Householder Application for Planning Permission for works or extension to a dwelling. Town and Country Planning Act 1990

PROPOSED DORMER WINDOWS TO THE FRONT,
TOGETHER WITH A SIDE EXTENSION TO THE
BUNGALOW - see attached e-mail

RE: Proposed dormer windows to the front, together with a side extension to the bungalow
AT: 26 Whalley Road, Langho

scale: 1/50th drawing no:
date: Jan. 2012 12/1/2 A

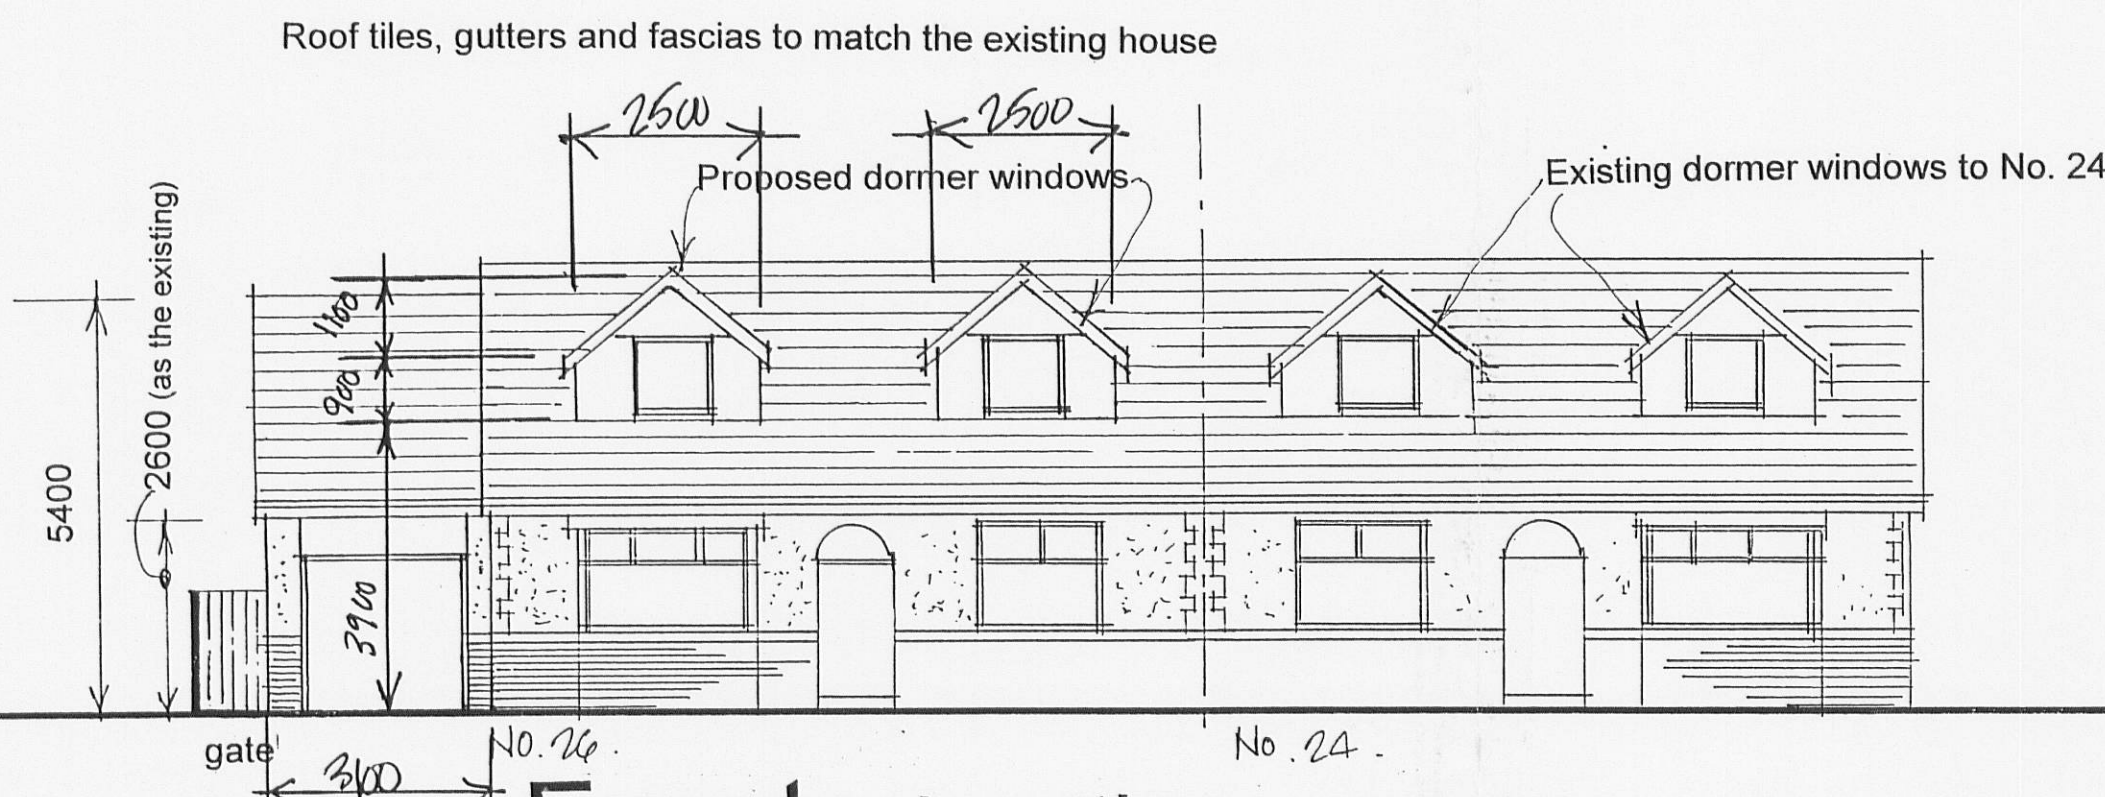
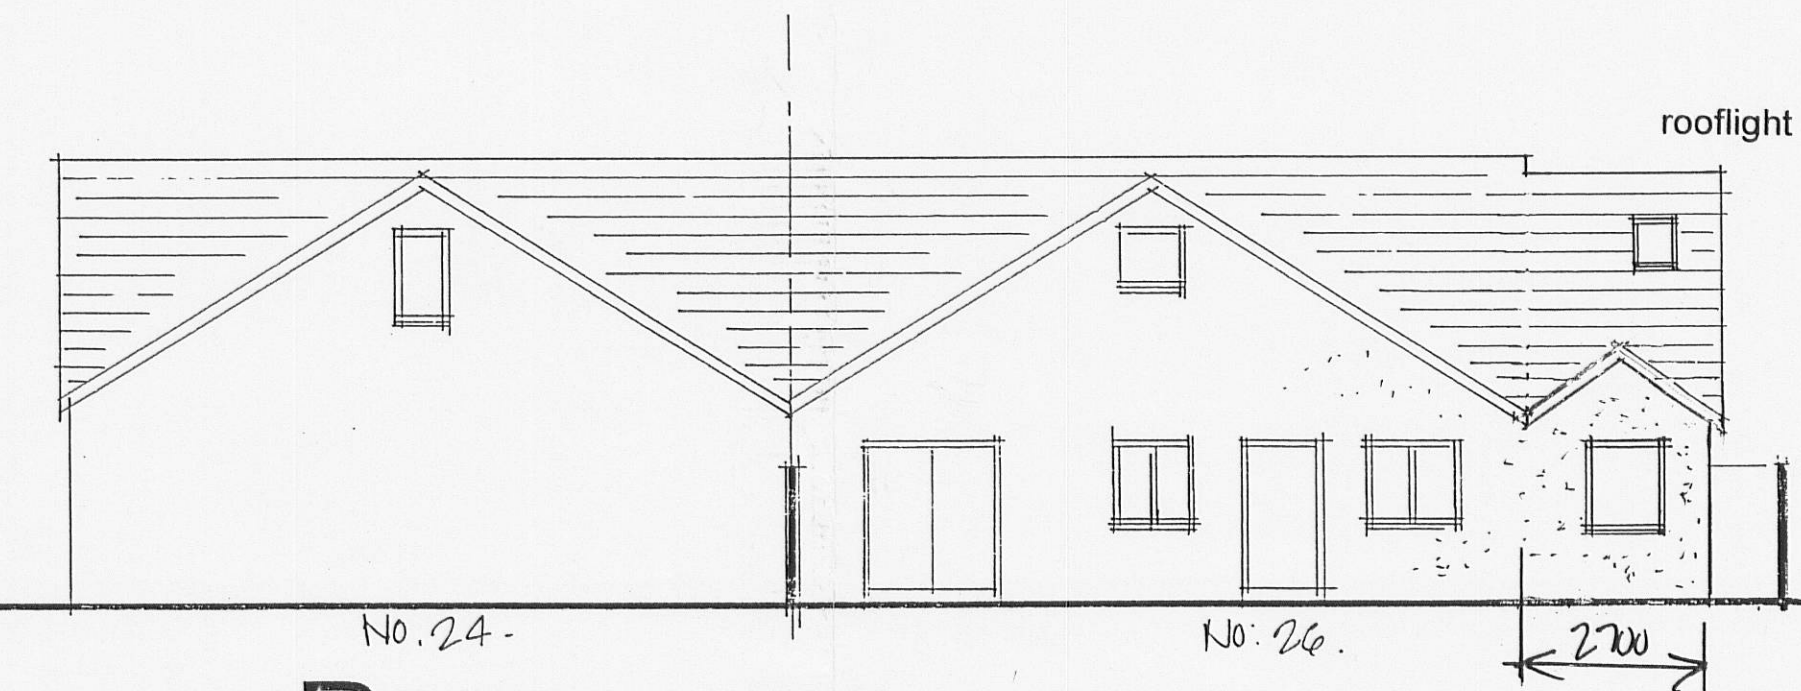
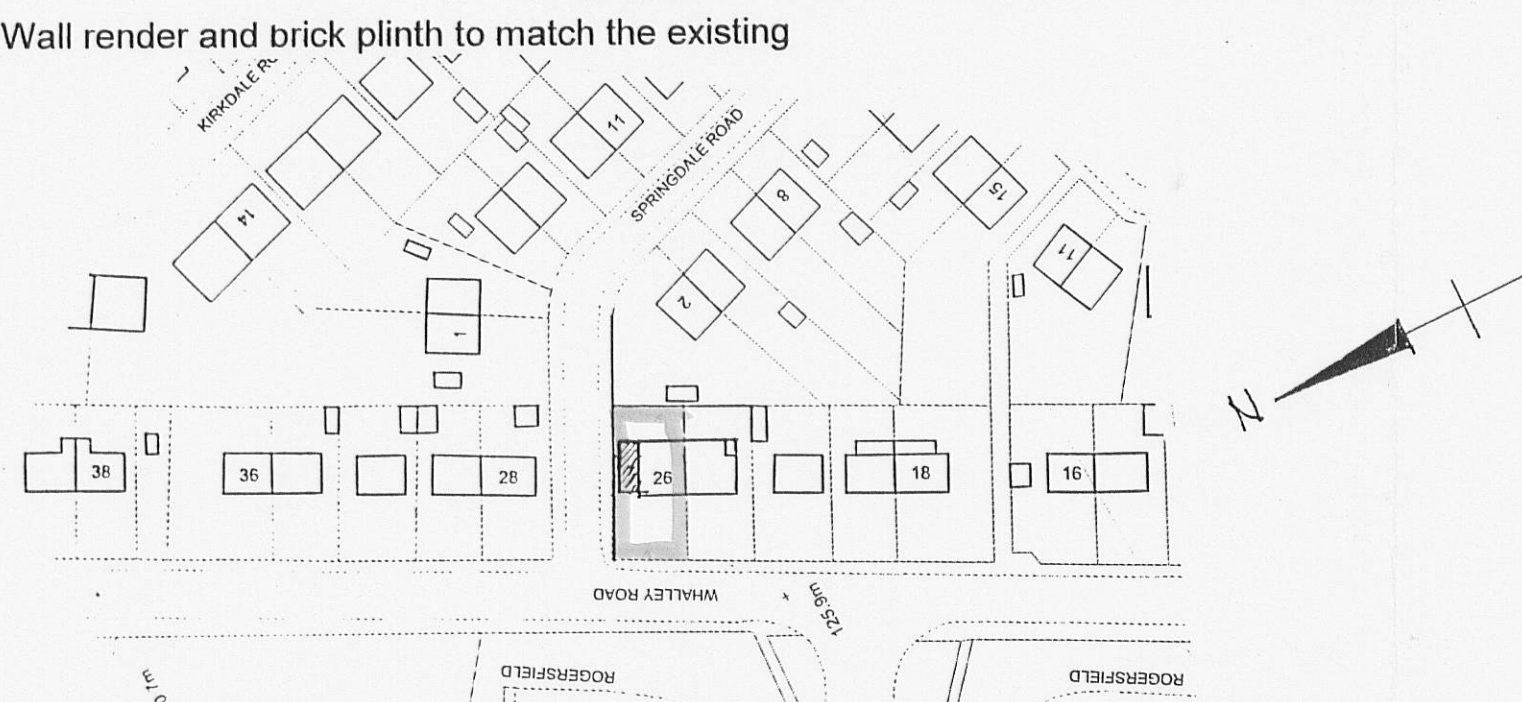
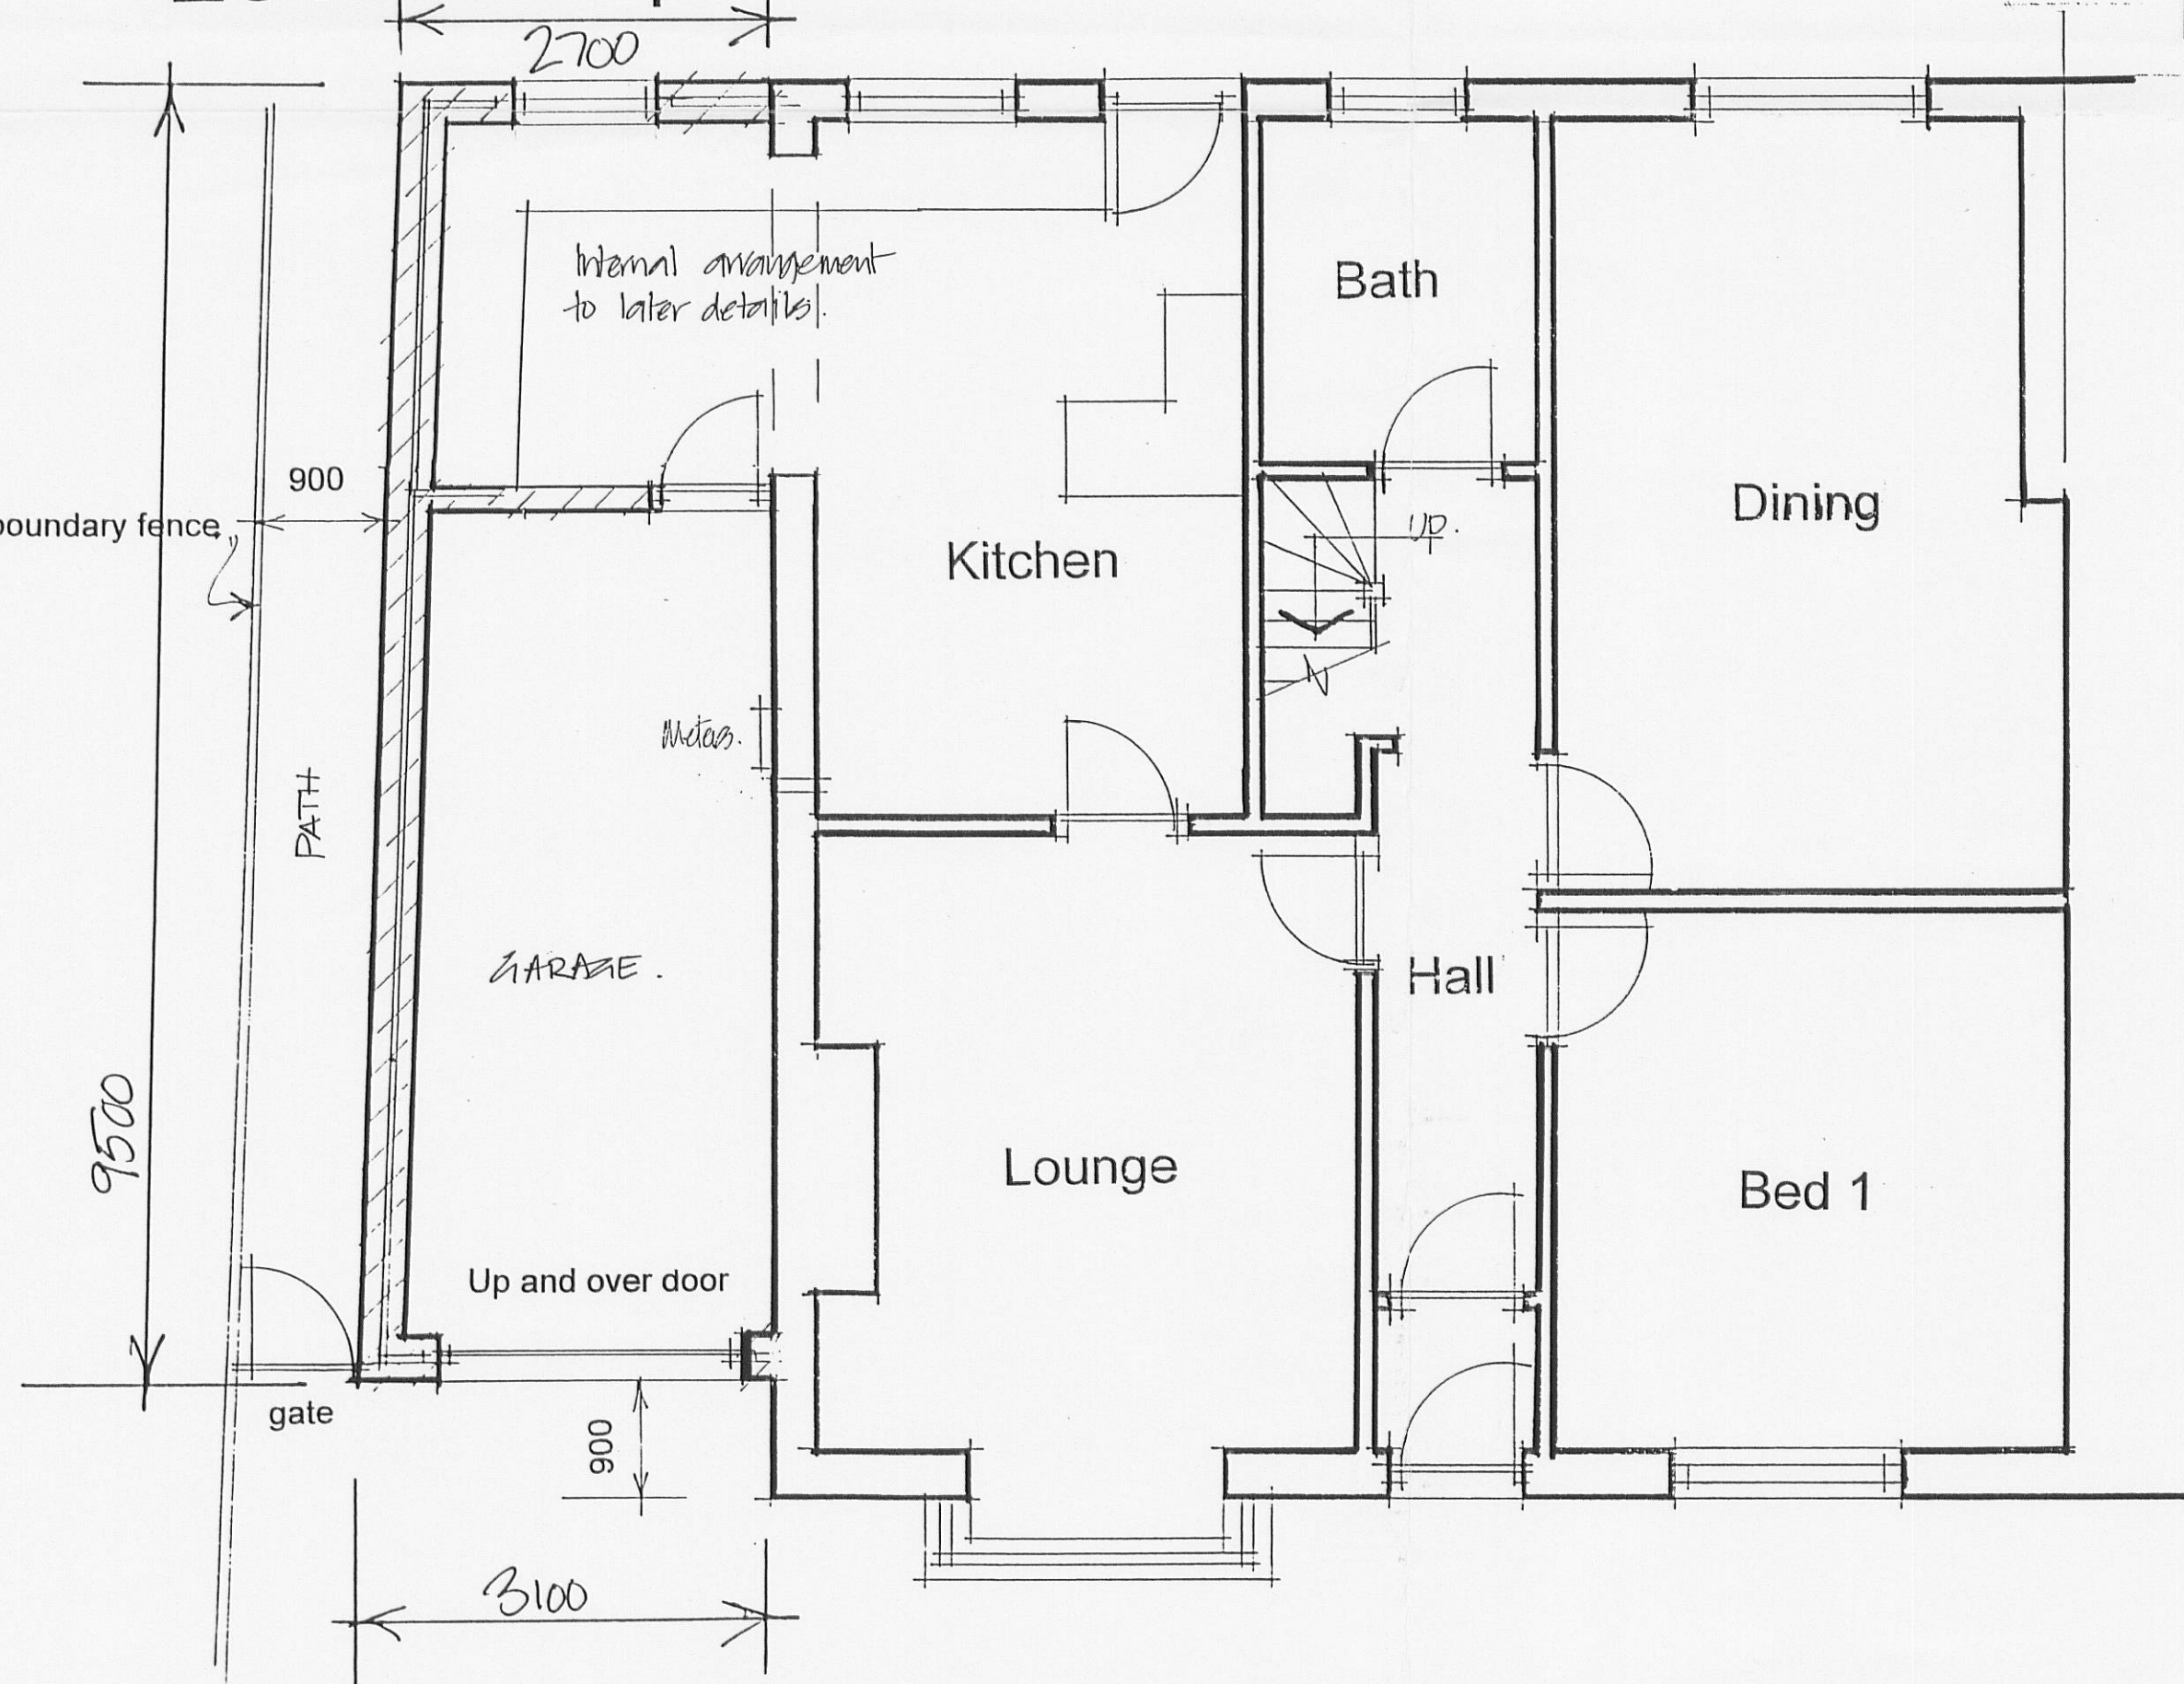
- All proposals need to be annotated with dimensions but only the height of the proposed extension is on the drawings. Please can you also add the overall external length and width of the extension. In relation to the proposed dormers please can you add the overall external height, width and projection.
- For clarity please can you show on the existing drawings that the garage will be demolished - either a label or highlighting/hatching will be fine. Also, please can you confirm that you are happy for 'Demolition of existing garage' to be added to the description.
